DECISION DELEGATED TO HEAD OF PLANNING

Application No: H18-1047-24 **Applicant:** Mr T Bissett
Proposal: Proposed workshop conversion to dwelling, including lifting of existing roof
Location: Workshop Rear Of 9 New Road Fronting King Street Sutton Bridge
Terminal Date: 31st March 2025

Proposed Street Scene 1:75

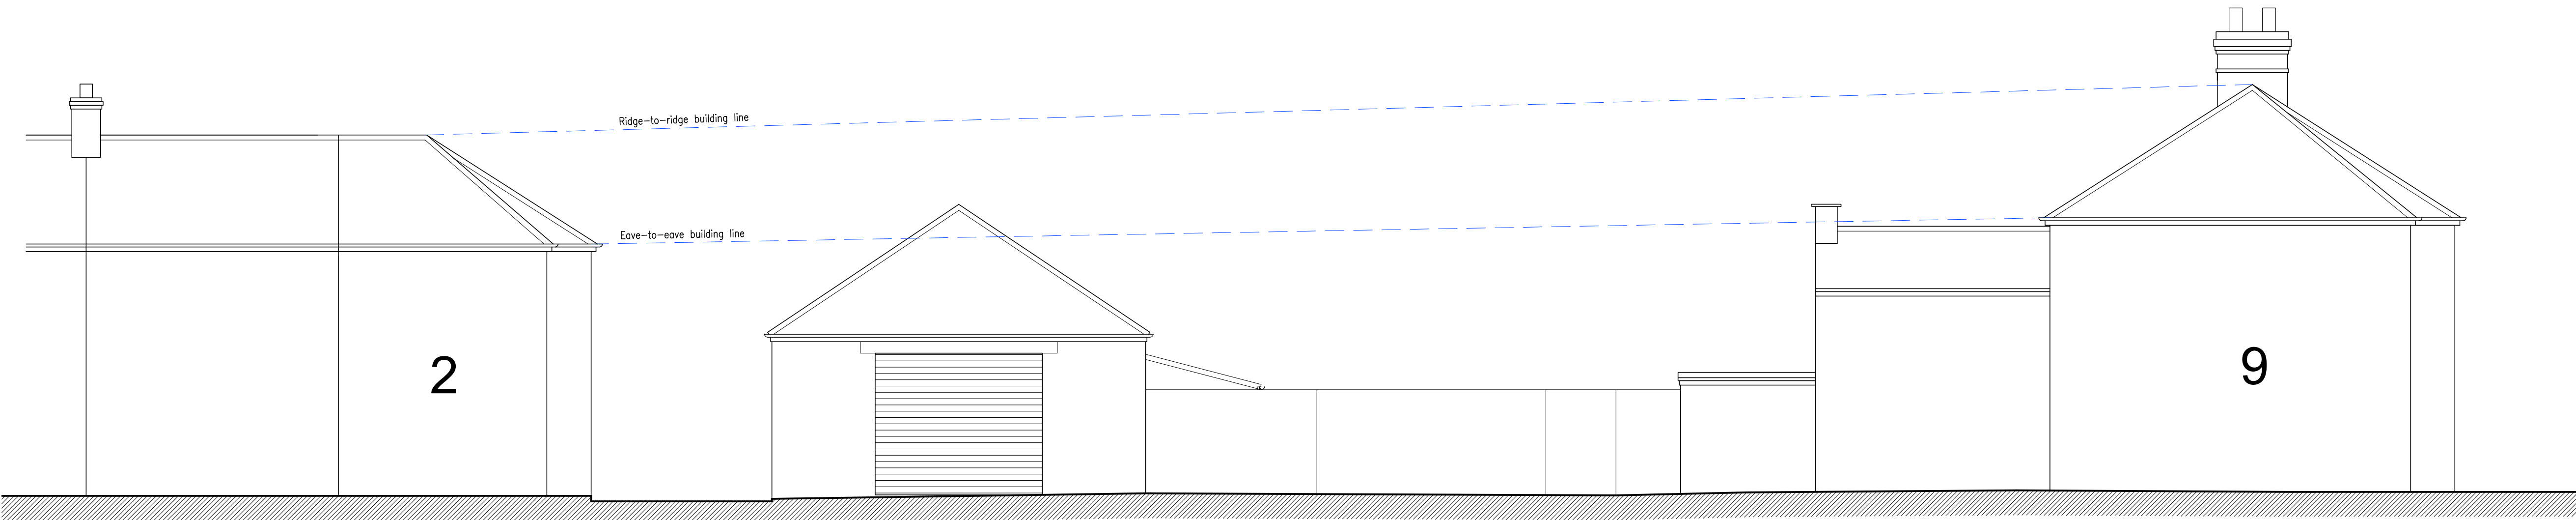
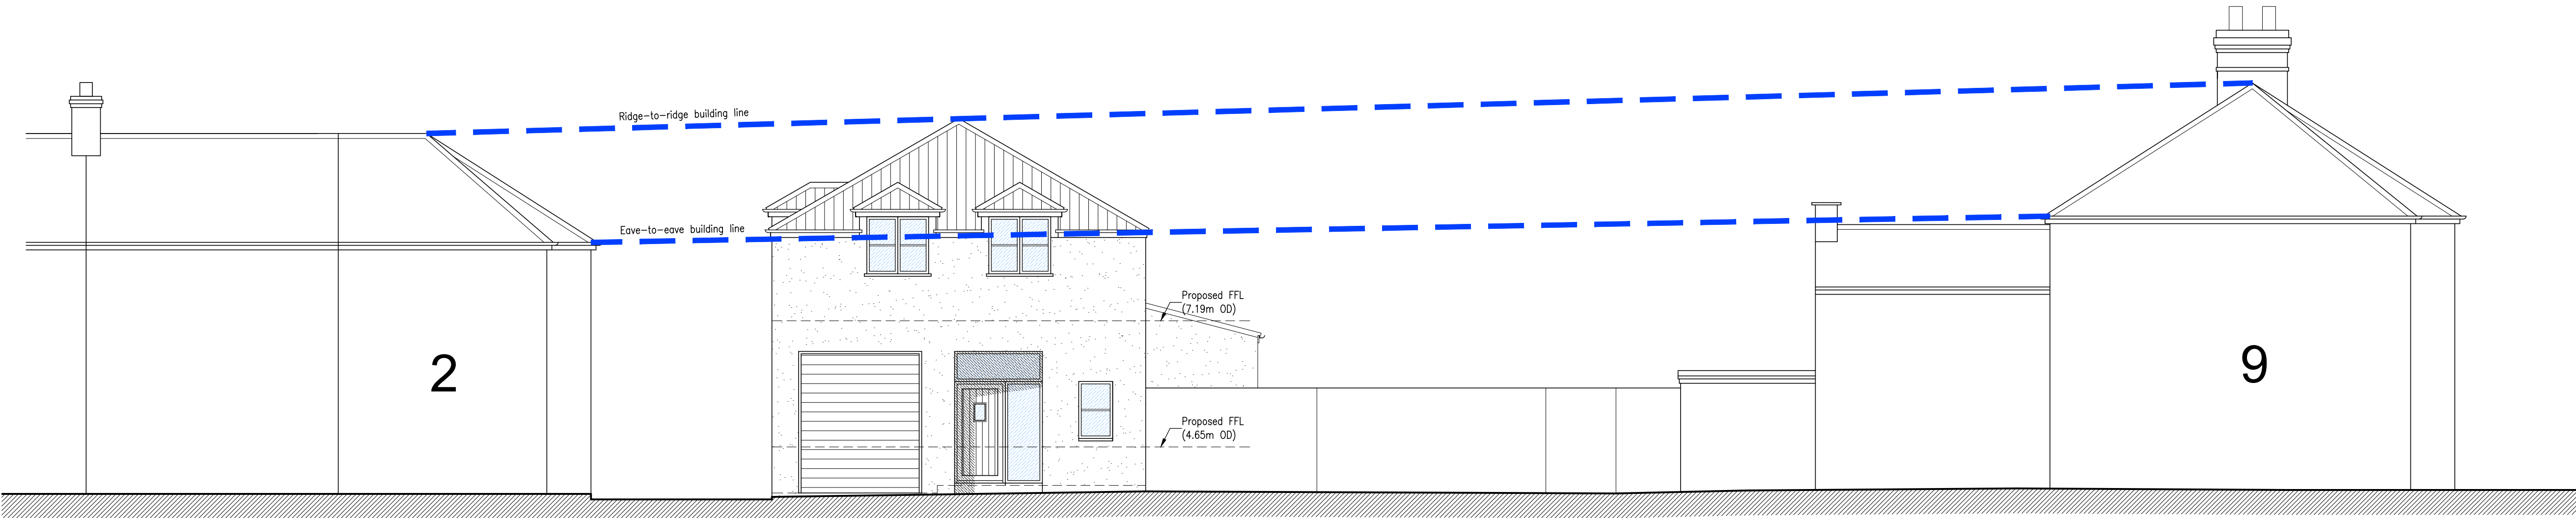
The height of the conversion would take it somewhat level to the eaves and ridge of 2 King Street, sitting at around 5400mm (eaves) and 7600mm (ridge). Whilst this is a notable increase from the existing workshop, detailed street scene and section drawings have been provided which demonstrates the development's suitability within this environment in this regard, as it is not

Notwithstanding this, the application site is relatively small in size and when viewed with regard to its immediate surroundings does not reflect the prevailing character in respect of the plot size or its siting amongst other independent dwellings. Given the small and contrived size of the plot, the proposal to convert the workshop to an independent dwelling would result in a somewhat cramped and contrived form of development.

Proposed Section 1:50

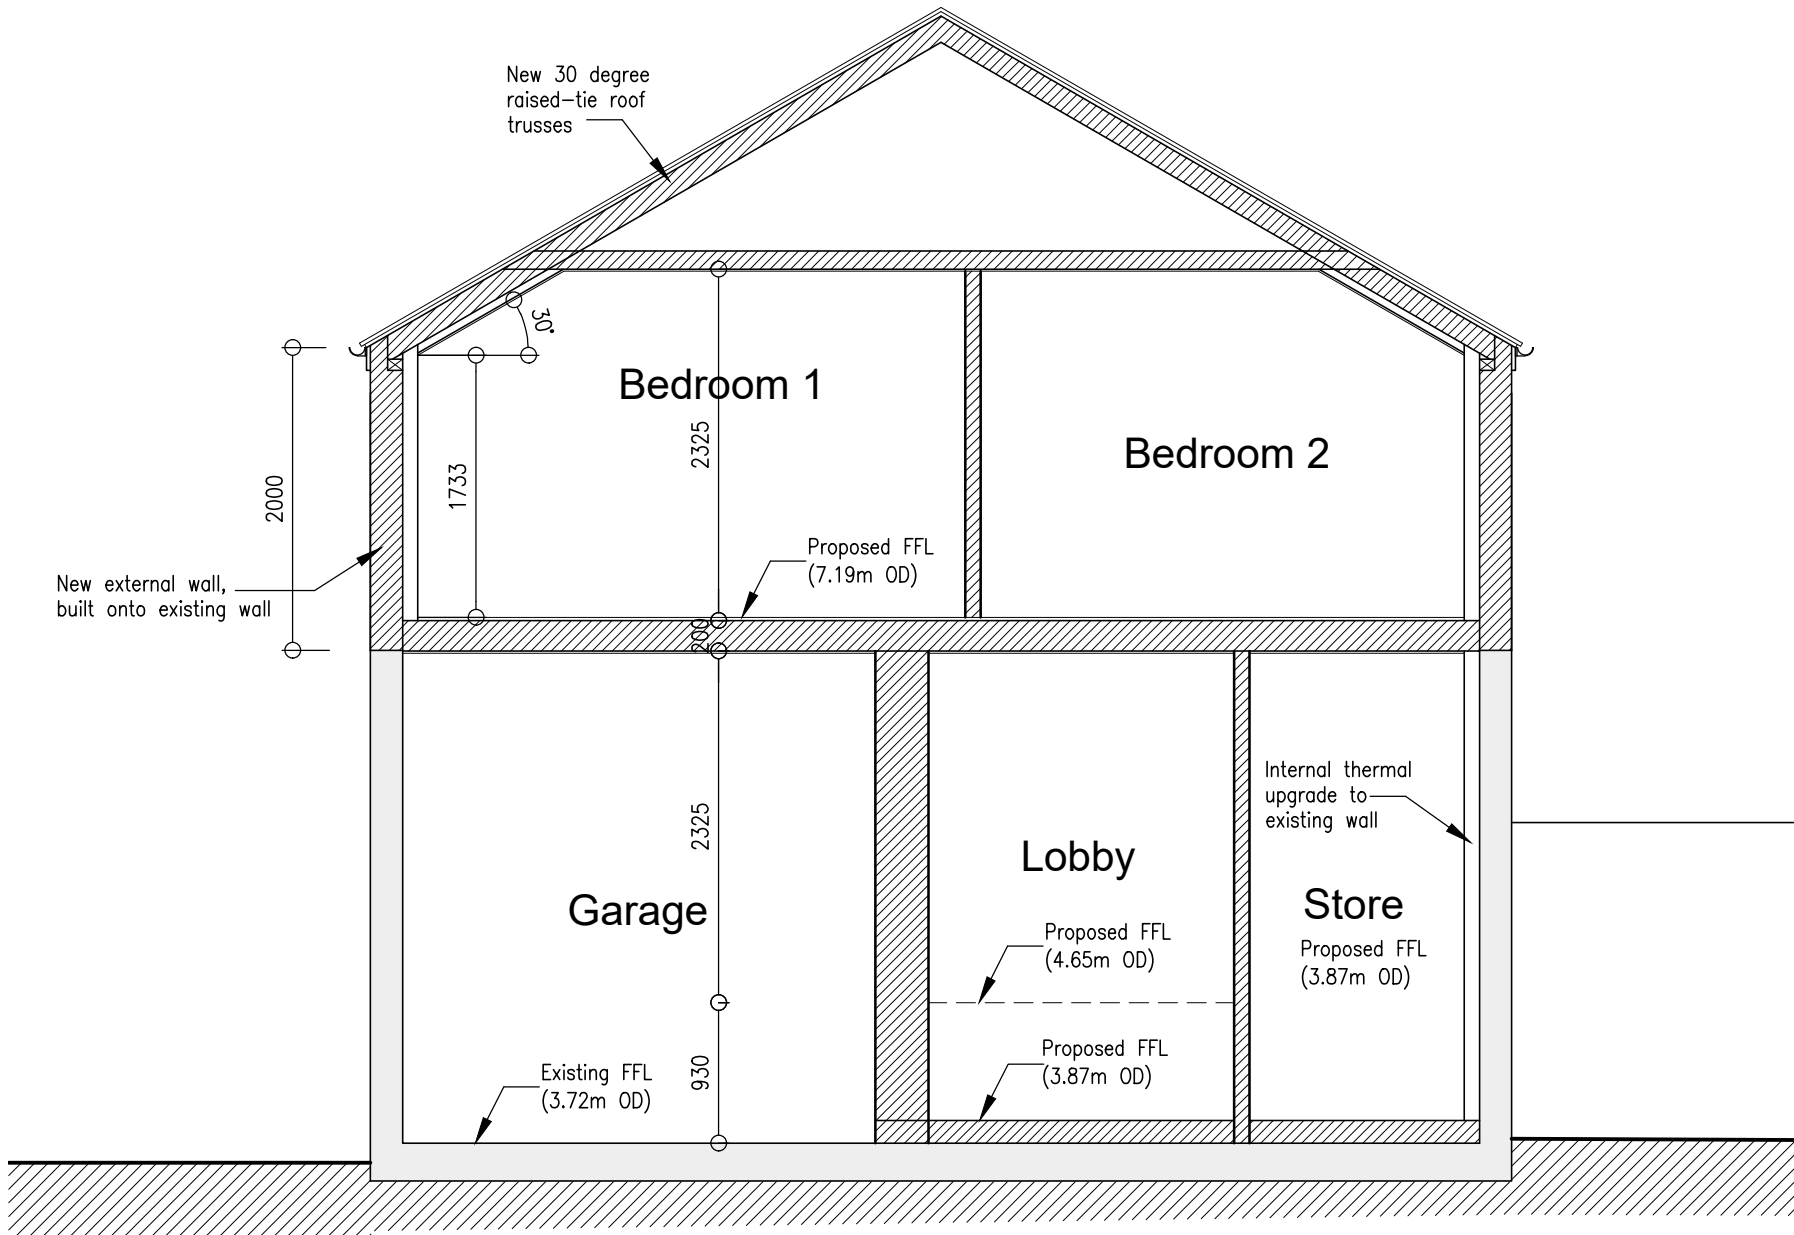
Both the Flood Risk Assessment and Environment Agency's comments require the finished floor levels to be set no lower than 4.65 metres above ordnance datum. This would result in the finished floor level being set at 1m above surrounding ground levels. When taking this into consideration, being a requirement in respect of ensuring adequate flood risk mitigation, would give rise to concerns of material overshadowing from the proposed dwelling, due to its two-storey scale of a 7600mm height, as also required by Environment Agency's comments, further to the aforementioned requirement to have a finished floor level of 1m. This would result in an unacceptable impact on the residential amenities of neighbouring occupiers, particularly due to the height and positioning causing a loss of light to No. 9's rear garden.

Proposed Rear Elevation 1:100

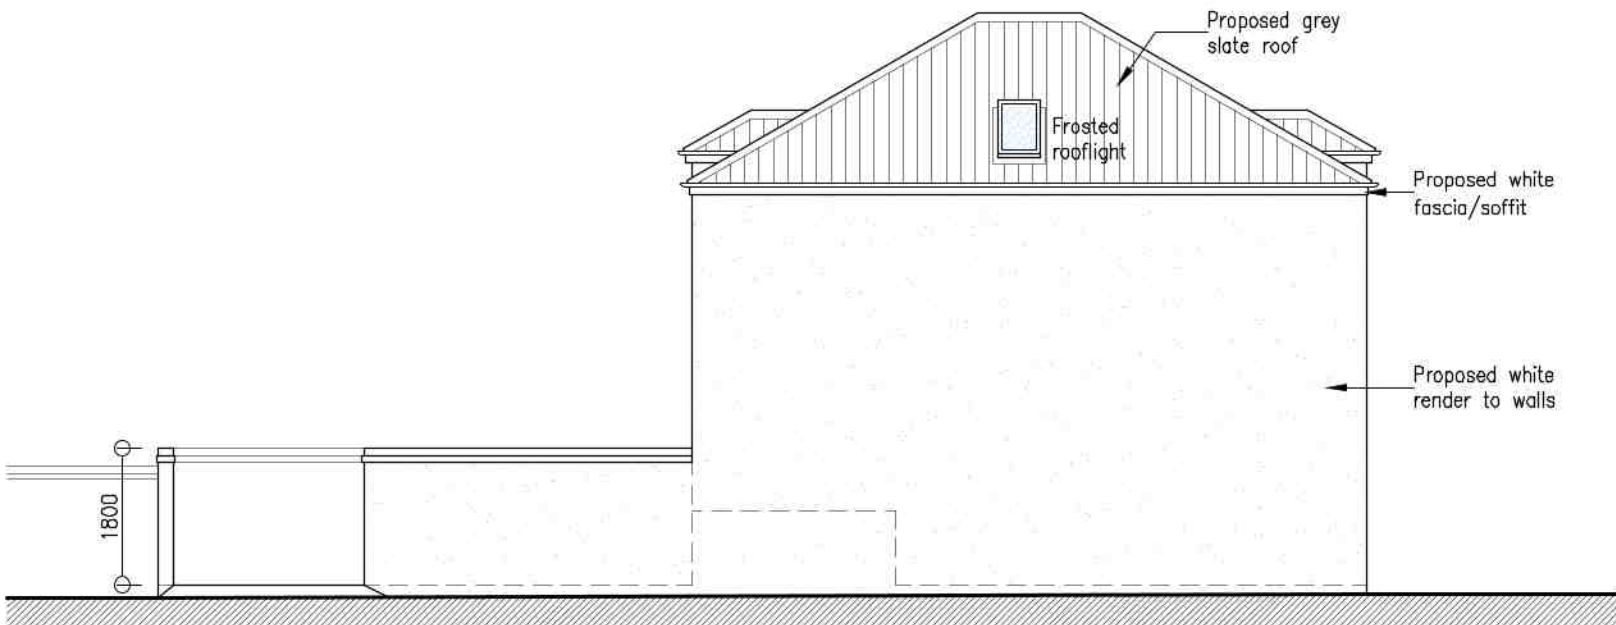
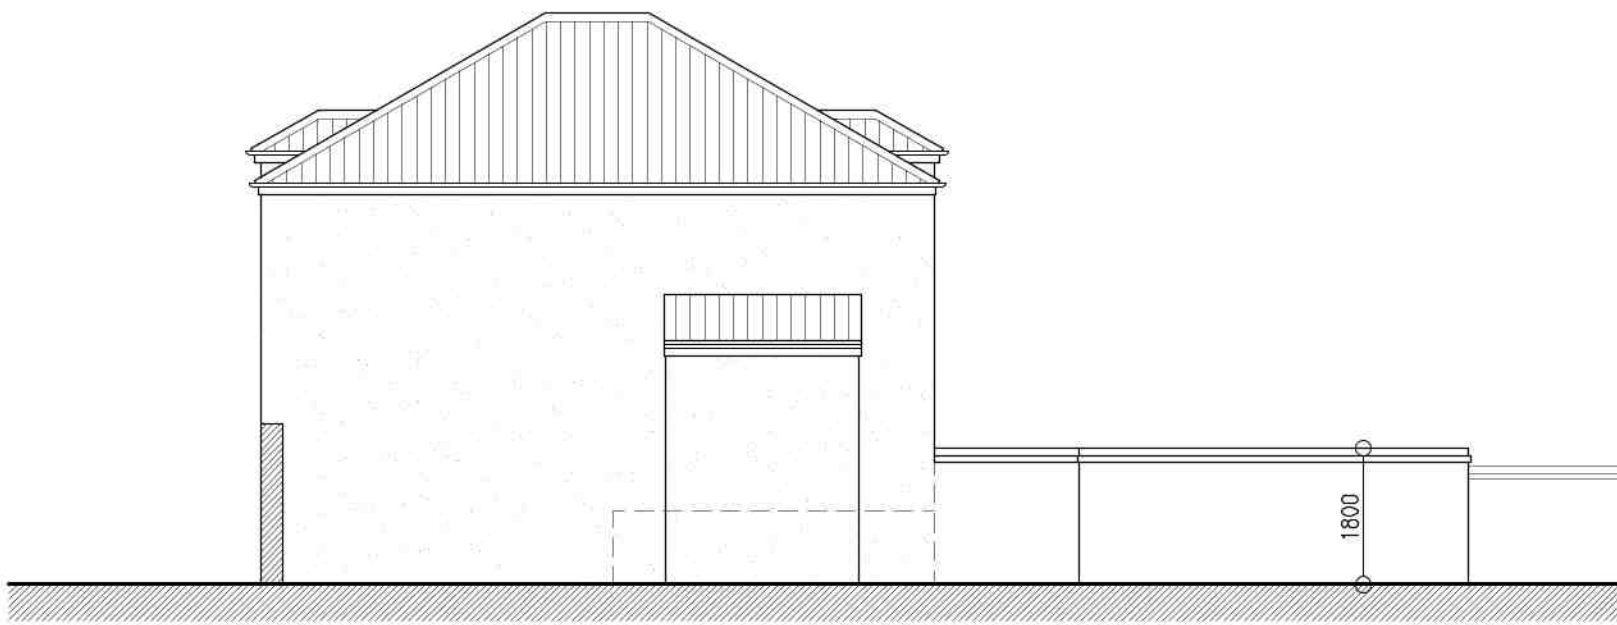
No windows are provided on the western elevation; this would ensure that no material overlooking would occur to any existing neighbouring properties to the west. There would be no concerns to the southern/front elevation due to the orientation of the proposal, facing onto the public highway.

Notwithstanding this, the first floor rear elevation windows overlooking for the living room and Bedroom 3 would directly overlook the amenity space of 13 New Road, as this elevation would be set only 7m to the south of this. This relationship is not considered to be sufficient and there would be a direct loss of privacy. The same could also be said about the potential for the family/dining area, plus outside landing to overlook, as the FFL would be raised in such a way that the boundary wall would be rendered obsolete.
